Transport for NSW

30 October 2023

TfNSW reference: WST21/00253/03 | SF2021/285613

SSD-29508870 for Birriwa Solar Farm at Barneys Reef Road and Birriwa Bus Route South, Birriwa. (various land parcels)- response to RTS and Amendment Report

Figure 3. Castlereagh Highway/Barneys Reef Road intersection upgrade (south)

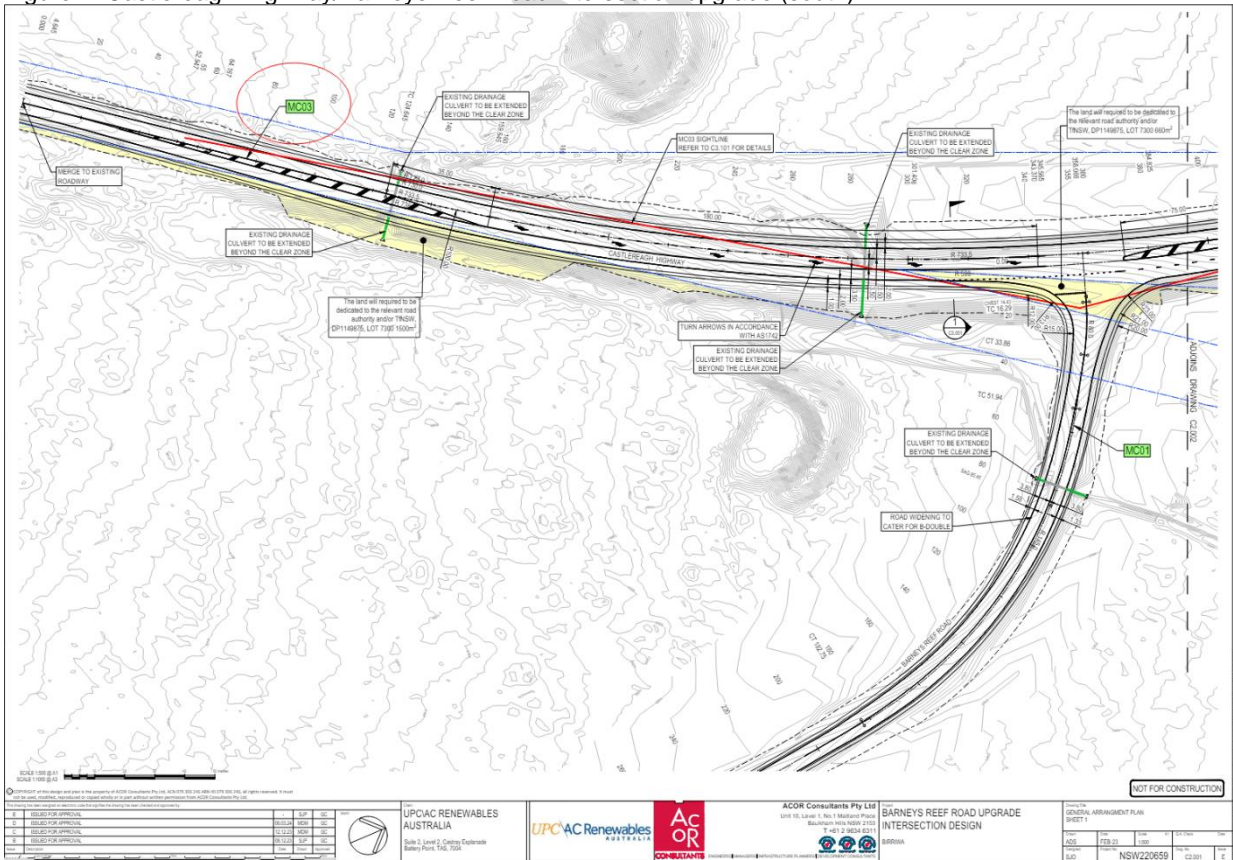
10. The strategic design provided for the Barneys Reef Road/Castlereagh Highway intersection reflects a Basic Right Turn and Auxiliary Left Turn treatment which is not representative of the existing turn warrant assessment which identified the requirement for a Channelised Right Turn and an Auxiliary Left Turn treatment. No justification has been provided for the revised scope of the treatments as a part of the RTS.

11. The Strategic Design will be required to be revised based on point 10 for the Barneys Reef Road/Castlereagh Highway intersection with the inclusion of swept path analysis showing concurrent passing in all directions for the identified design vehicle.

13. It does not appear that any measurements have been provided as a part of the Amendment Report or response to the RTS of the compliance with Safe Intersection Sight Distance for the Barneys Reef Road/Castlereagh Highway intersection. The revised TIA is to include a measurement of the existing SISD at proposed intersection at the Barneys Reef Road/Castlereagh Highway intersection, if SISD is not compliant then measures to achieve compliance will need to be identified as apart of the revised TIA and if required the necessary measures to achieve compliance will need to be included within a strategic design for this intersection.

Note: The existing TIA identifies that a 2.0sec reaction time is suitable for the 100km/hr+10km/hr design speed, TfNSW will not support a 2.0sec reaction time for a 110km/hr an hour design speed. The correct reaction time is 2.5sec which would require 300m of SISD in each direction.

Further to this point, TfNSW adopts a 10km/hr above the posted speed zone as the design speed on rural roads.
